## ADC PARKS &amp; GREENSPACE ARBORICULTURE

PLANNING APPLICATION: AB/142/14/T

ADDRESS: Riverside House 2 Fitzalan Road Arundel BN18 9JS

BRIEF DESCRIPTION: Various surgery to 8No. trees

TREE PRESERVATION ORDER NUMBER 2/1982/AB

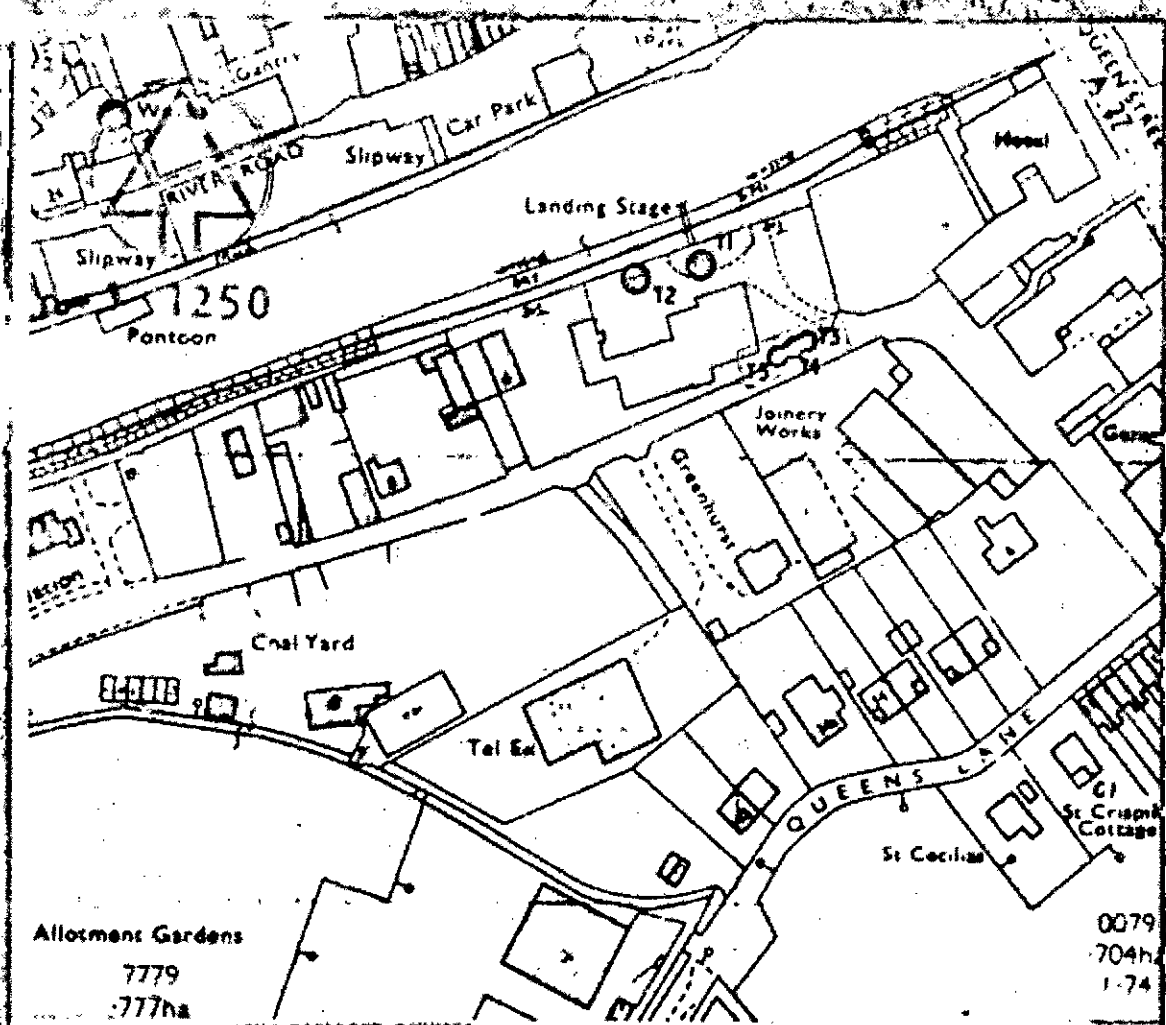
- The applicant has requested various works on the outlined trees. these are as follows;
- **T1** – removal of 5 branches (as indicated on a submitted photograph) and a 1.5 meter lateral reduction only. The branches indicated for removal are the lowest 5 branches that span laterally out to the north, off a primary leaning north limb. These small diameter branches have clearly had some suppression from the rest of the crown, and are subsequently not in great condition. The applicant has also requested a lateral reduction of 1.5 meters. From the site visit it is clear that this individual has had historic pruning. A lateral reduction of 1.5 meters would remove the regrowth back to these established pruning points.

- **T4** – is a tree that is actual situated outside the grounds of 2 Fitzalan road. This tree has evidently had a regime of all over reductions over a number of years. The applicant has applied the remove the regrowth back to these established pruning points.

**T1** – Removal of the 5 lowest branches on the north facing stem, and a lateral reduction of 1.5 meters only.

**T4** - a 6 meter height reduction only.

- The applicant should follow the following conditions for **T1**, **Tb**, and **T4** as they have active TPO protection;
